**Application: SSI 7485**

I write regarding the proposed modification to M4-M5 Link, Mod 2 The Crescent overpass and changes to pedestrian infrastructure in North Annandale, Rozelle and Rozelle Bay Foreshore area.

Figure 4-2 Pedestrian and cyclist bridge infrastructure options

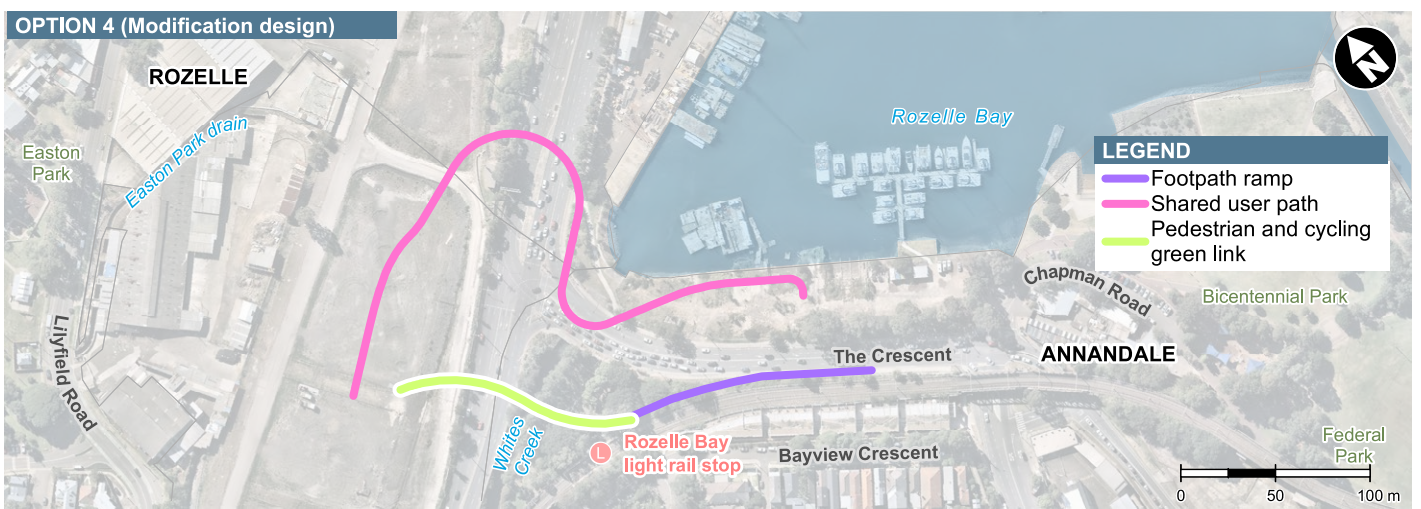
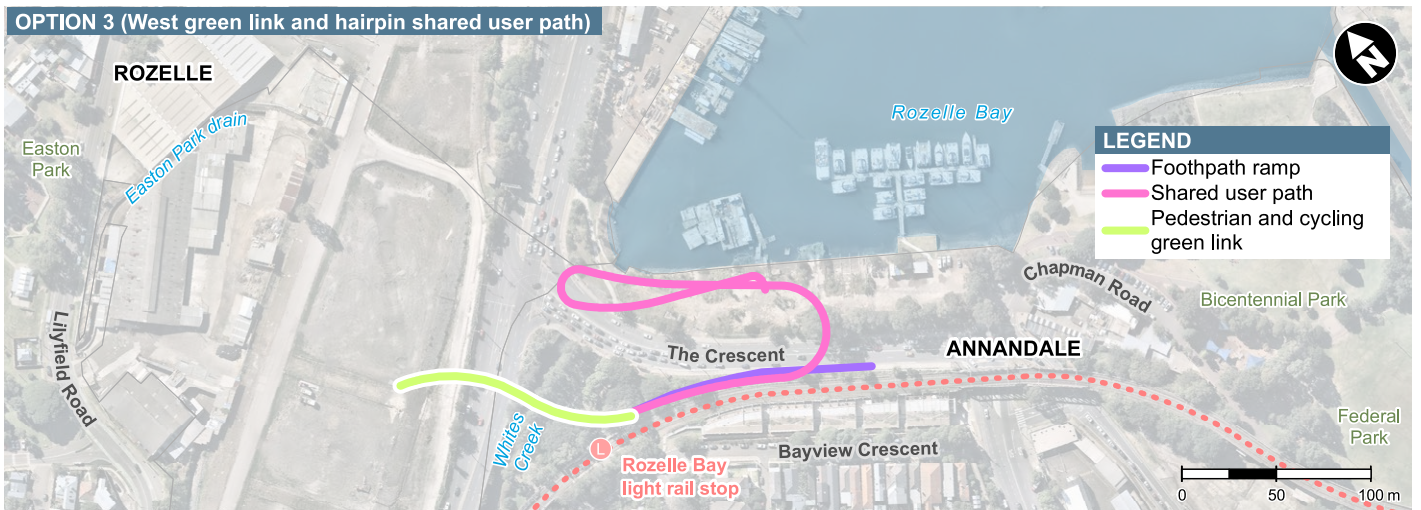
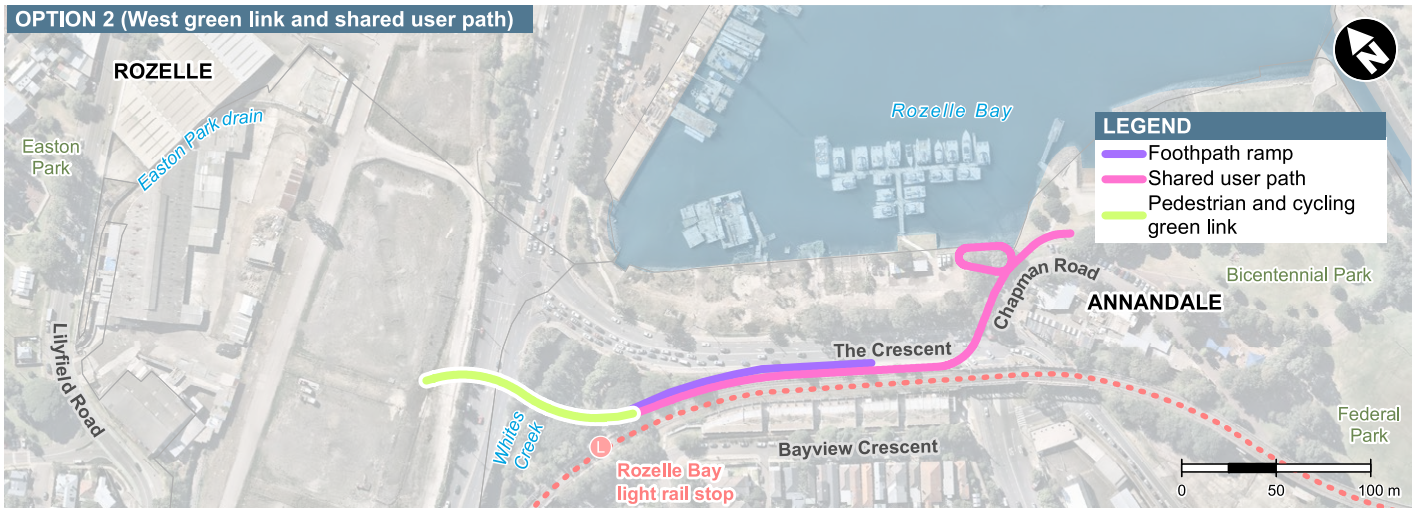
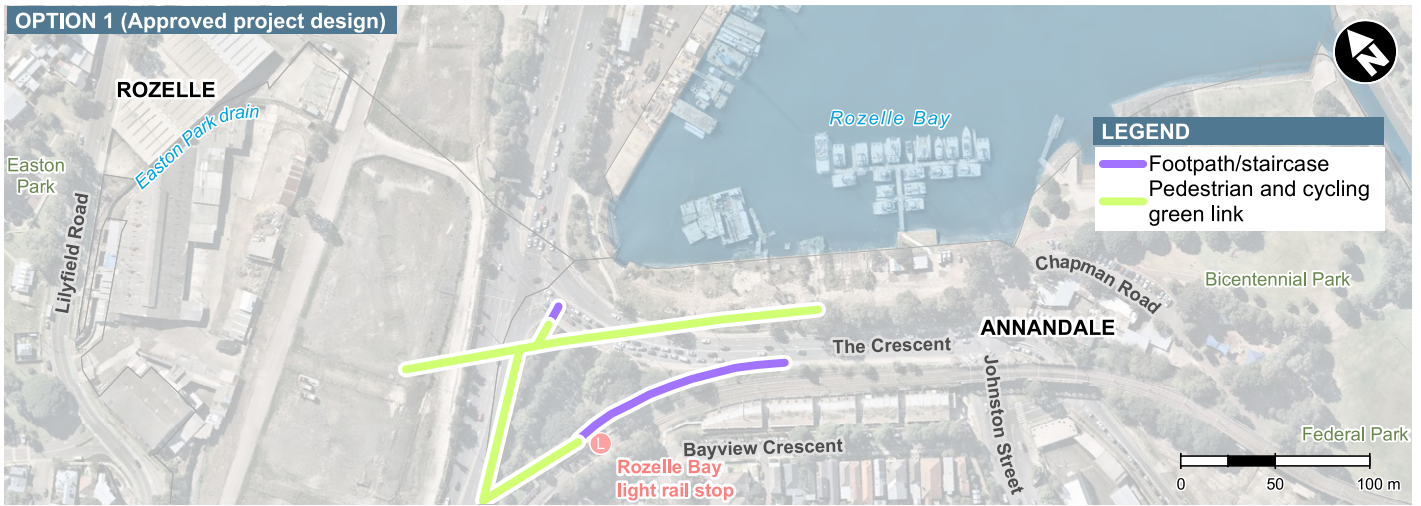
I request RMS work with the community to explore alternate design options to the proposed new car overpass design and the changed pedestrian and cyclist links. I am seeking the reinstatement of the safe, direct access from the approved EIS GreenLink to create a continuous green open space connection from the Rozelle Rail yards and Annandale to the foreshore. The GreenLink was more than just a walk way - it put people central to the design, maximising safety, and providing much needed accessible open space for the community now and into the future Bays Precinct design.

- The significantly reduced safety and increased risk for pedestrians and cyclists with removed access over The Crescent to Bicentennial Park and the increased traffic along Johnson Street.
- Being required to cross five sets of pedestrian lights at The Crescent as my option to reach the foreshore from Annandale or from Rozelle Bay light rail stop.
- Removal of direct active links to the foreshore, cutting the community off from the area and the proposed revitalisation of the entire Bays Precinct, including linking the Light Rail and Bus stops to a Ferry wharf and Metro station.
- Urban and landscape design that is being built before a finalised Masterplan for the area.
- Traffic changes that limit movements around the suburb and create further congestion in the local streets of Annandale, Forest Lodge, Glebe, Lilyfield and Rozelle with no planning to deal with these.

- Reinststate the GreenLink connecting communities and green open space from Rozelle to Bicentennial Park
- Relocate and design pedestrian and cyclist connections that are continuous, safe and direct.
- Design the modification infrastructure and active links in response to the character of the suburbs, the location of the foreshore and it's potential future development.
- Provide pedestrian and cyclist paths that maximise people safety and do not force them onto busier streets, unsafe concrete plazas and caged walkways.
- Integrate active and direct connections to all active transport - including the future Metro West and Foreshore Ferry Wharf
